Remodelling & extensions
Hascombe 33 Tamarisk Way East Preston

Thank you for your internet representation made on 19th October 2015 which has been recorded as '**an objection**' with the comments as follows:

client	Jason Richardson
job	Hascombe Tamarisk Way East Preston West Sussex
dwg no.	1043.06e
title	Proposed Ground & First Floor Plans
drawn by	SM
checked by	KT
scale	1:100 @ A1
date	05.08.15

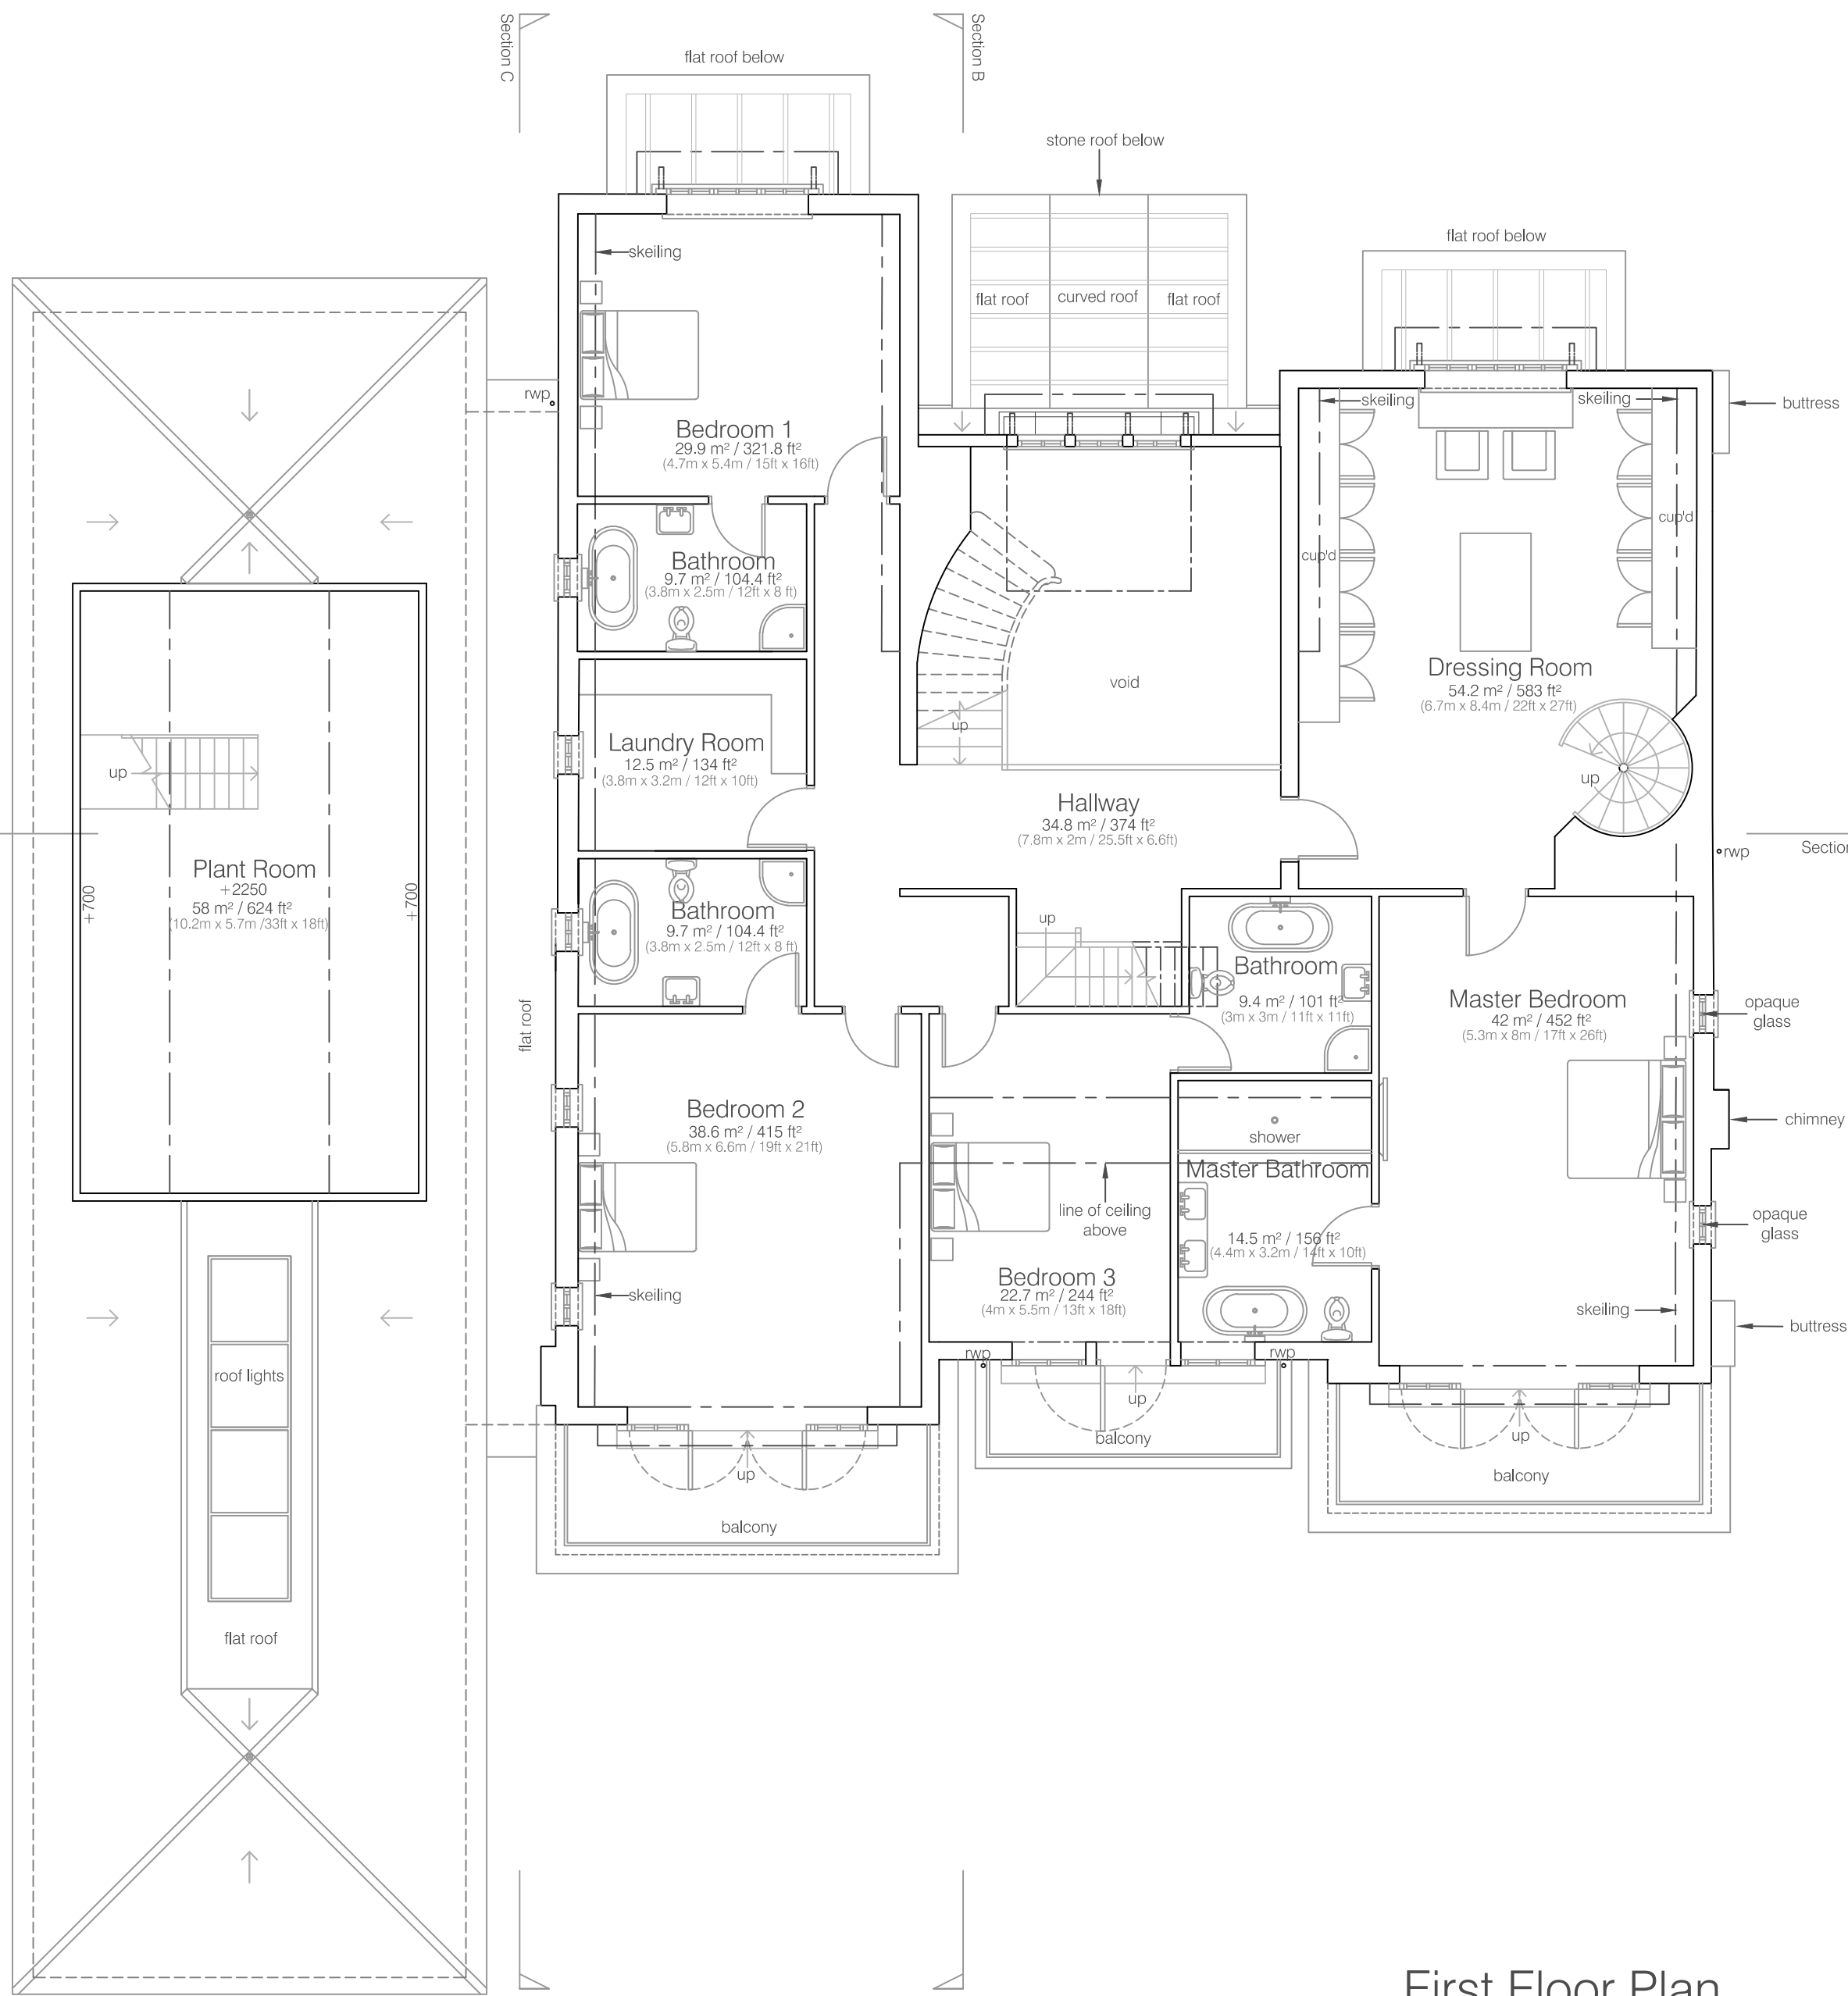
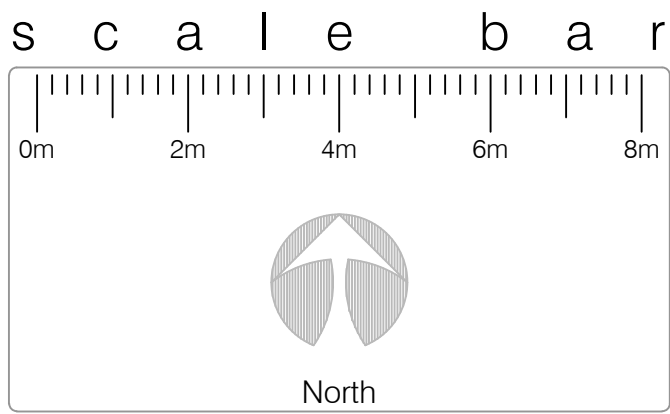
I am concerned how overbearing this new property would be on 31 Tamarisk Way and it would most certainly block out a lot of natural light, especially considering they plan to extend the first floor by such a considerable amount.
